MECKLENBURG COUNTY  
Park and Recreation Department

MEMORANDUM

**RE:** Rezoning Petition #2023-011  
PID# 04521224

C1.01

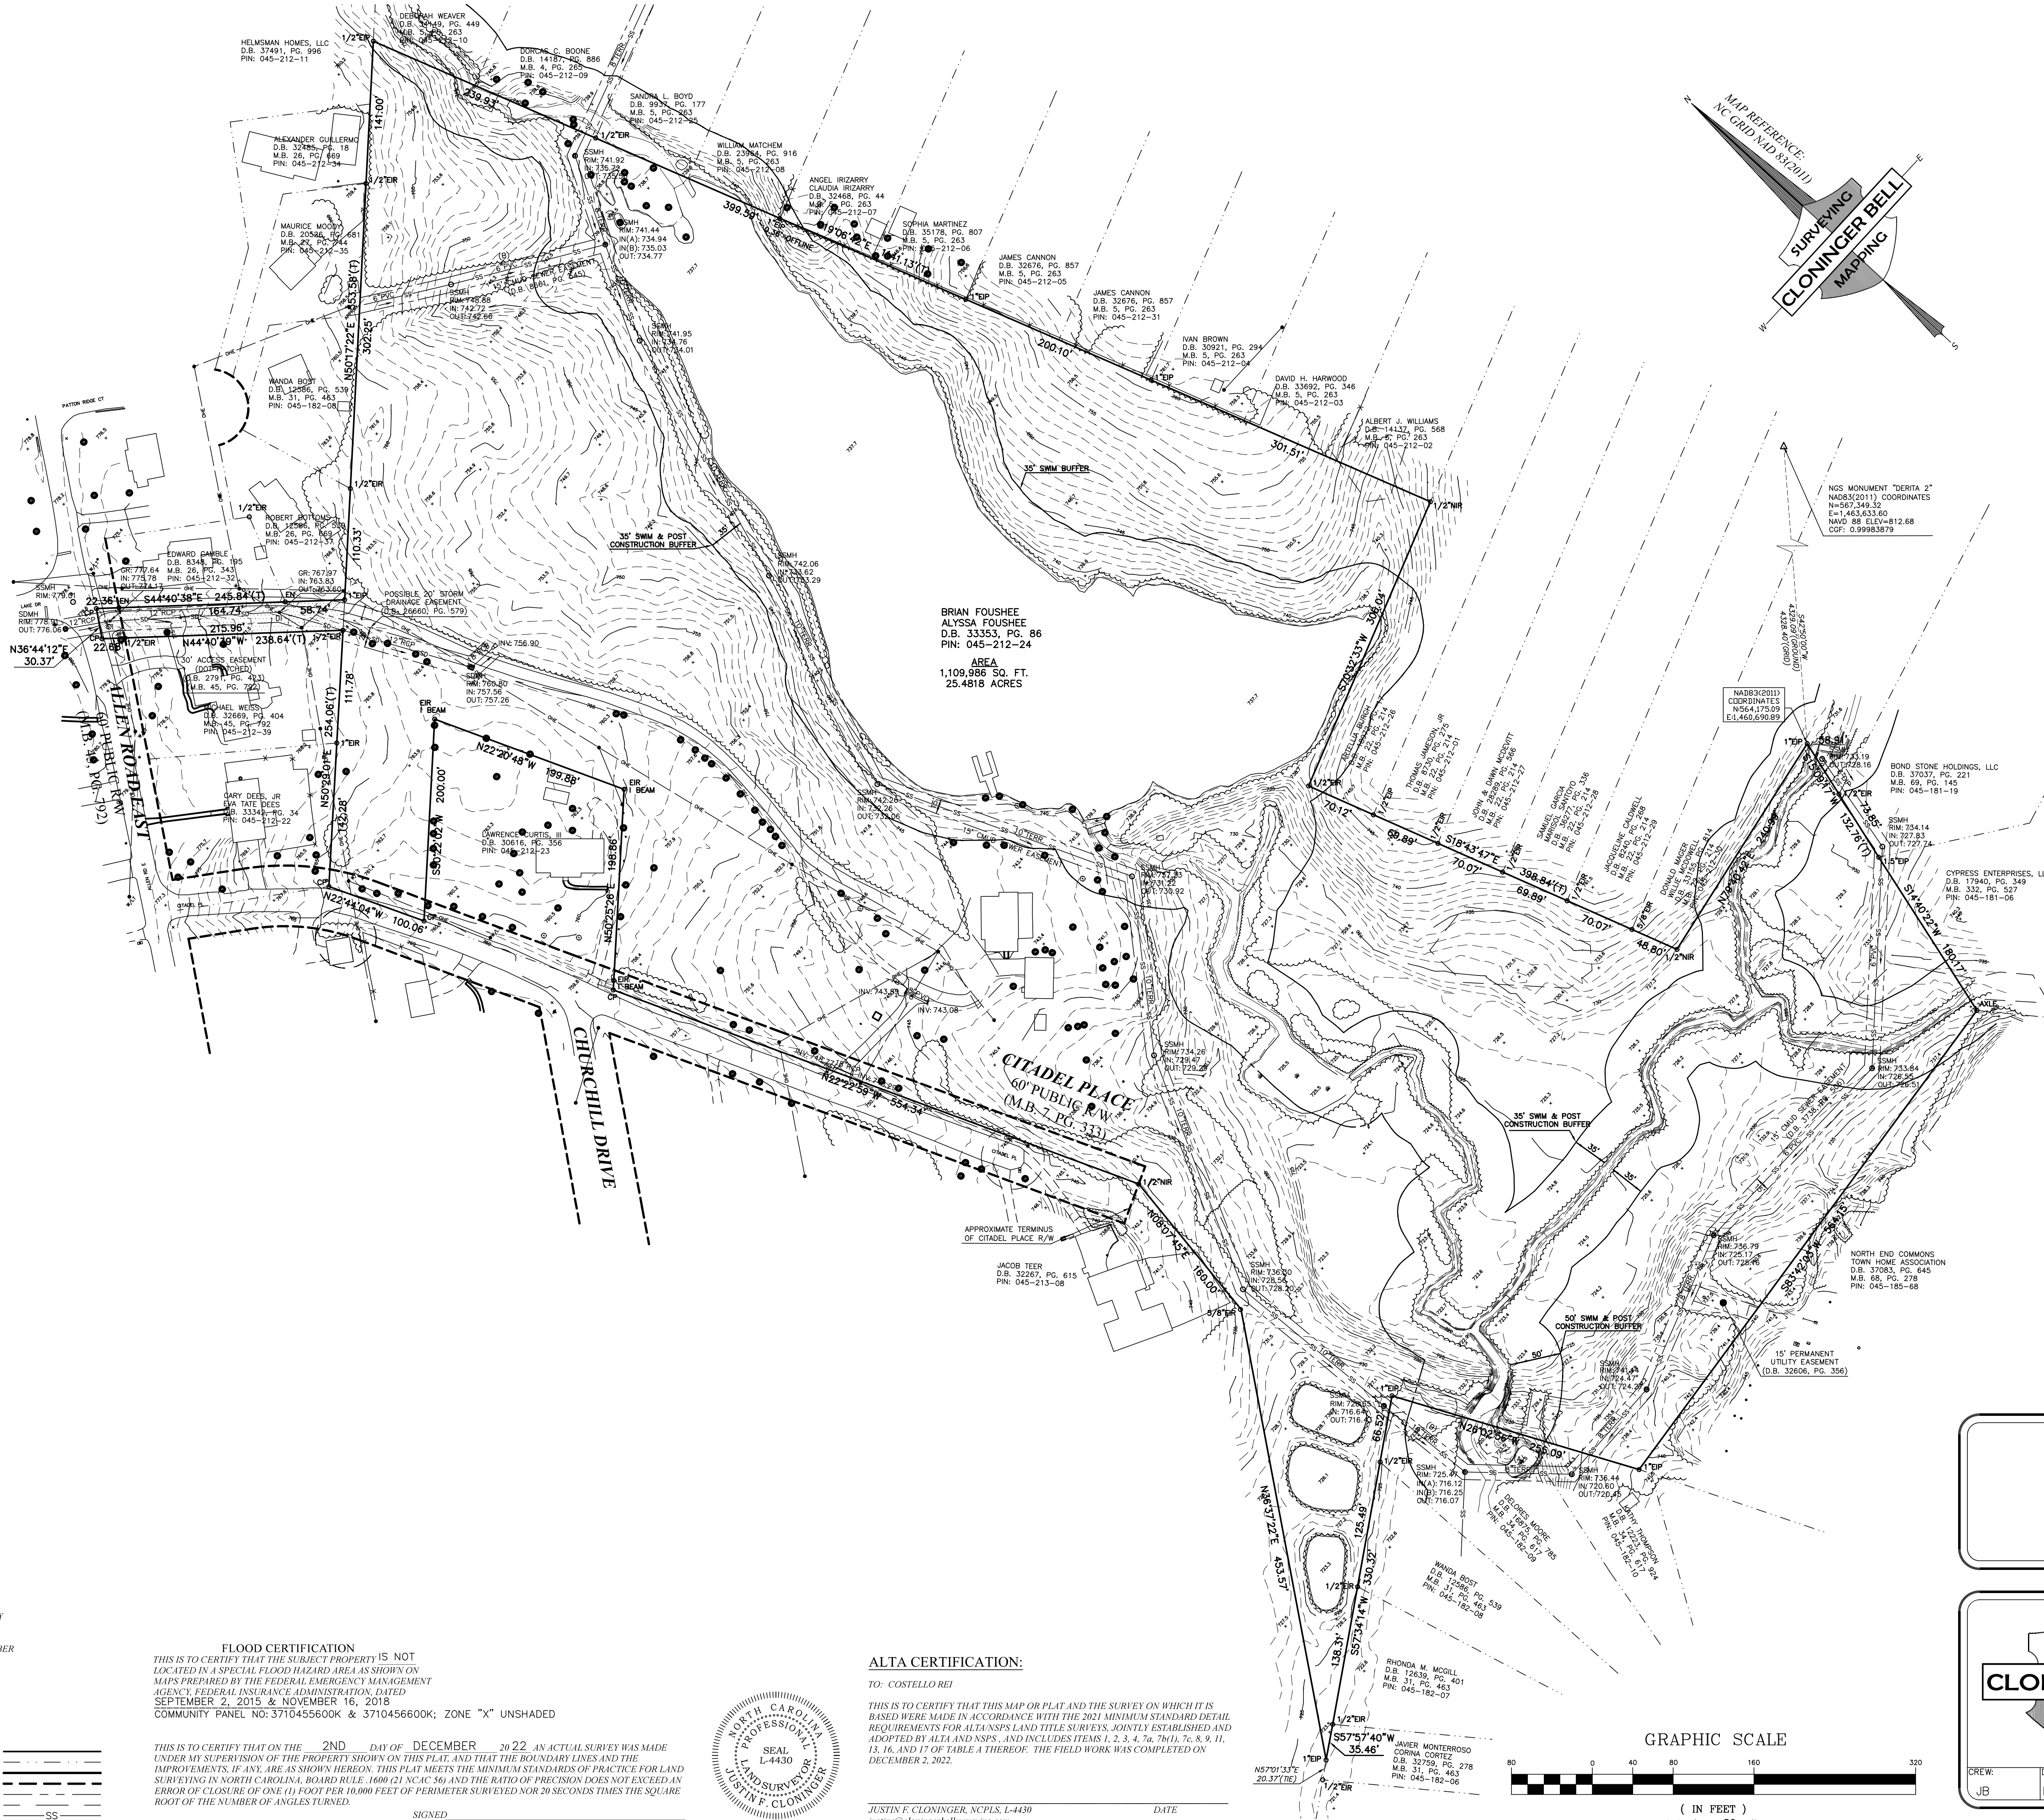
MCPR requests a minimum of **1.25** acres to be dedicated and conveyed to Mecklenburg County for a future neighborhood park. This requested park land shall be adjacent to a public right-of-way for access and is conducive for the development of the typical amenities found in a neighborhood park and cannot include tree save parcels or stormwater BMP's.
